An Environmental Impact Statement (EIS) in support of a State Significant Development Application (SSDA) for the construction and operation of a new multi storey car park at Liverpool Hospital was publicly exhibited for a period of 28 days inclusive between 28 May 2020 and 25 June 2020 (SSD 10388).

This report, prepared by Ethos Urban on behalf of the applicant, sets out the responses to the issues raised and includes design amendments made to SSD 10388 in accordance with Clause 55 of the *Environmental Planning and Assessment Regulation 2000* (EP&A Regulation) for which approval is now sought.

LHAP MSCP: Overland flows during construction
TTW 07/08/20

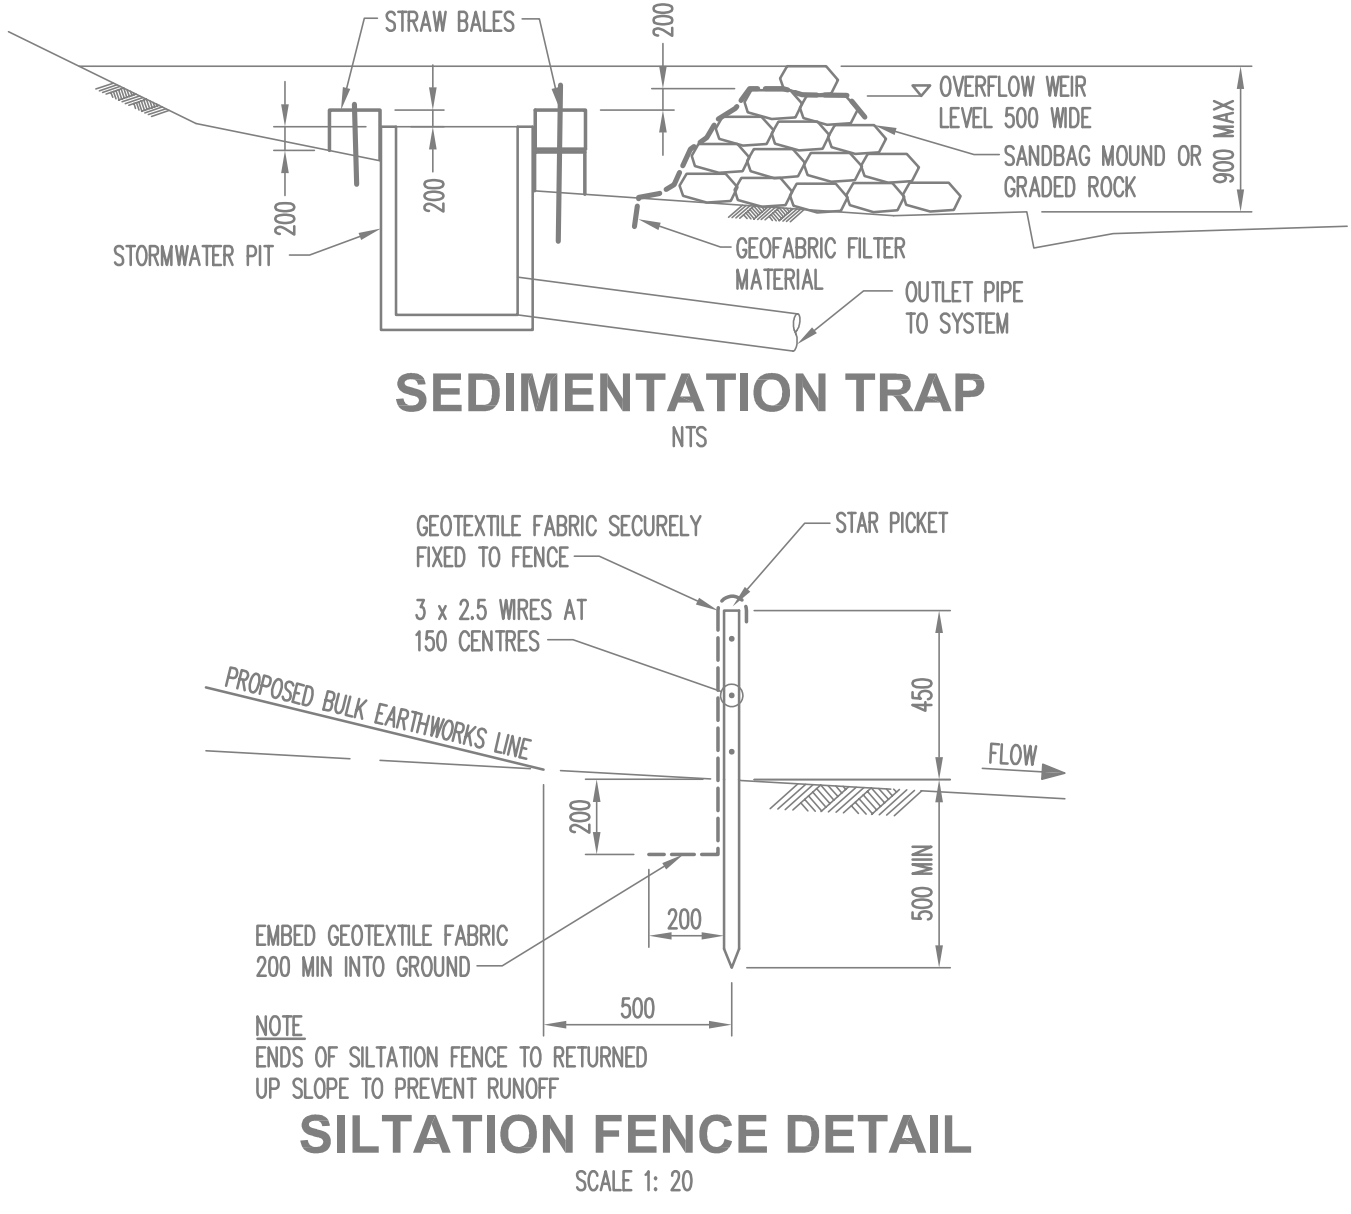
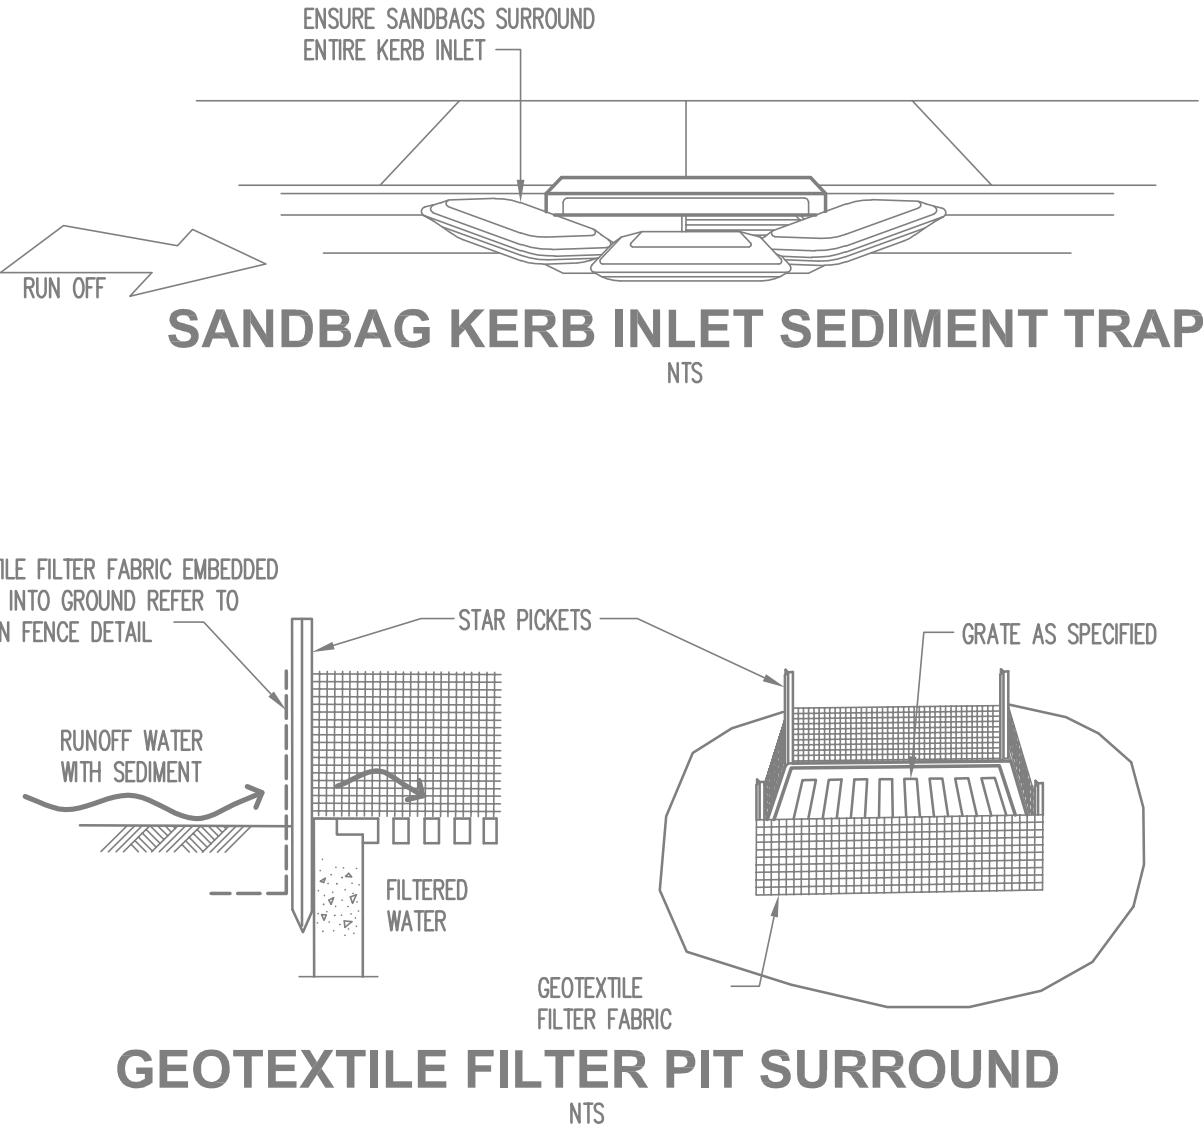
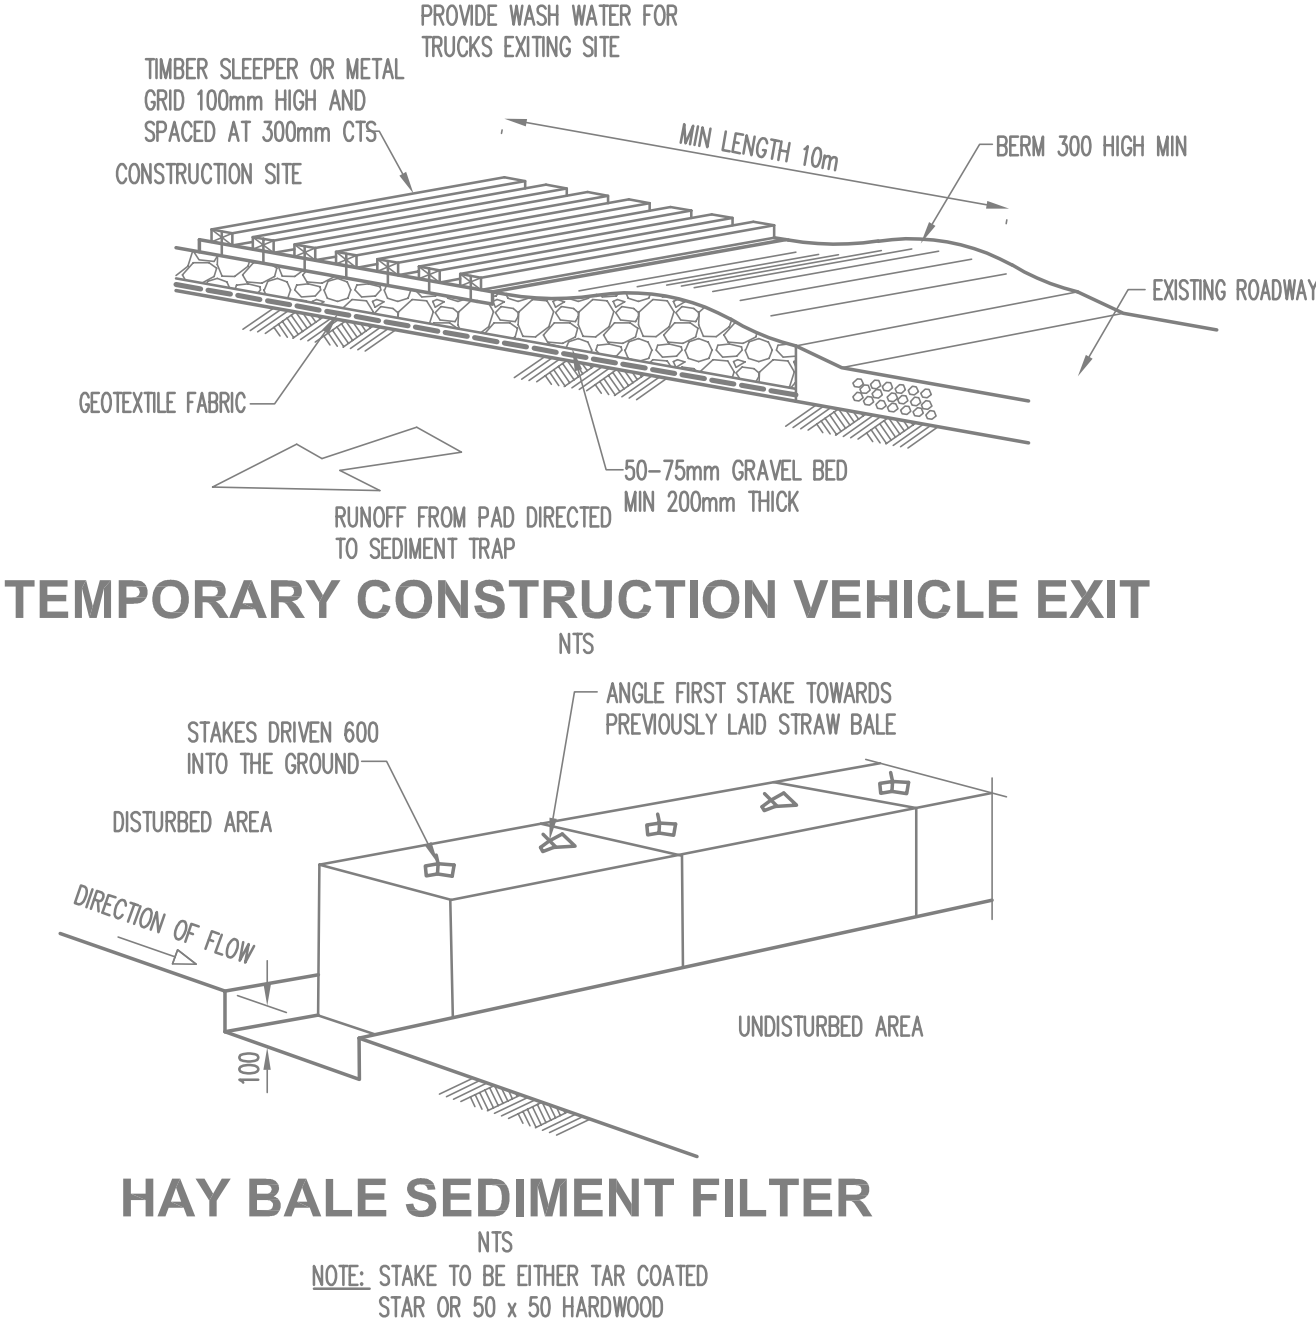
The applicant sought clarification of the DPIE request regarding flooding and DPIE seeks information on how stormwater would be managed during construction and following the completion of construction, given that flows would be altered during the construction of the development and once it is complete.

Plans illustrating the existing, during construction and post construction overland flow directions have been prepared by TTW. The plans illustrate that all overland flow from the construction site will be managed through siltation fences, sediment traps or filter pits. As shown in **Figure 1** to **Figure 4** below, the proposed construction works will not impact any external overland flow paths and during the post development scenario, overland flows are consistent with the pre-development overland flows. The overland flow path analysis is included at **Appendix L**.
